# **Technical Response to the Appellant's Highway & Transport Statement of Case Appendix 1 to Statement of Case of the Local Planning Authority (Kirklees Council)**

**Appeal reference:** APP/Z4718/W/25/3375000

**Application reference:** 2024/91242

**Site:** Land north east of, Shepley Road, Stocksmoor, Huddersfield, HD4 6XW

Scale @ A1	Date Created	Drawn	Checked
As shown	28.01.25	WO	CK
TPS Project Number		Revision	
P2835		P4	
Drawing Number 24071-LE-00-ZZ-DR-D-0001

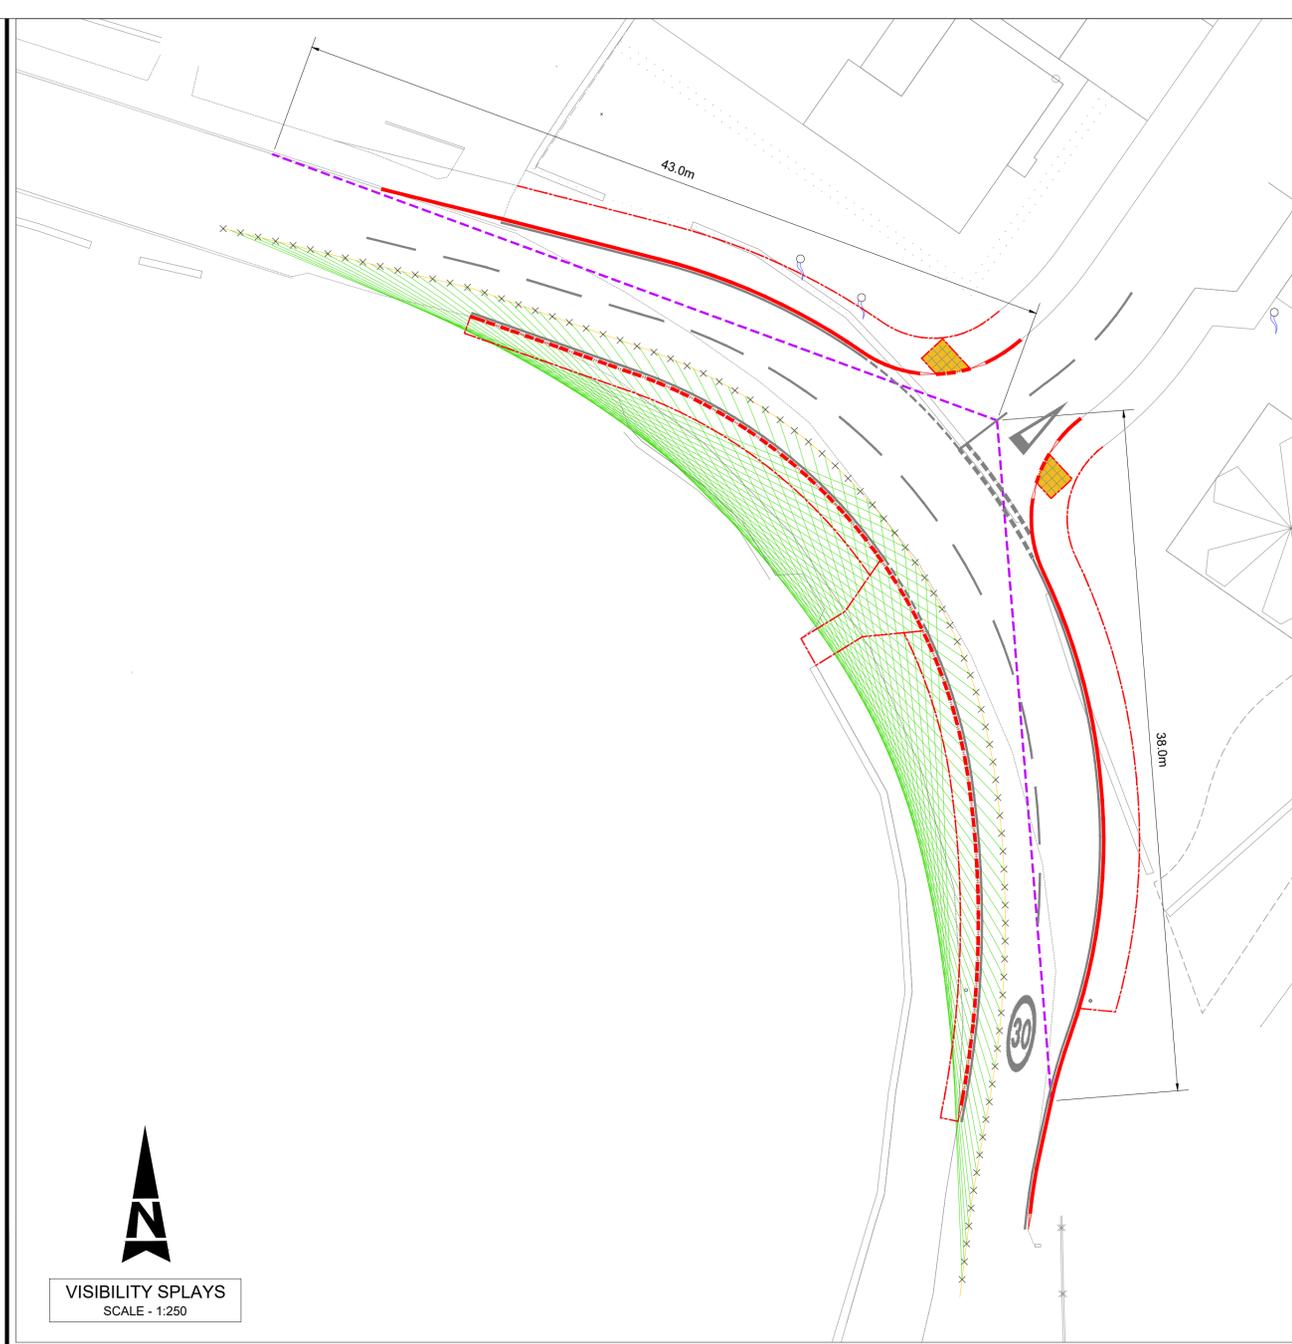
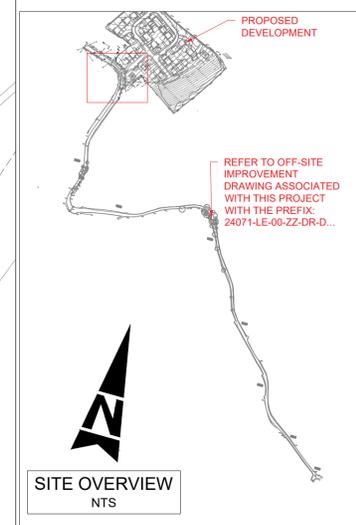
23. The revised site access arrangements (shown on drawing 24071-LE-00-ZZ-DR-D-0001-P4) included in the Transport Assessment Addendum report addressed the main outstanding issues raised in relation to the site access. Therefore, it was confirmed in the final HDM consultation response of 11/04/25 that there was no objection to the principle of the proposed site access, and that any further changes that may be required, including any changes that may arise from the required Stage 1 Road Safety Audit process in due course, could be addressed via a suitably worded planning condition. This remains the case.
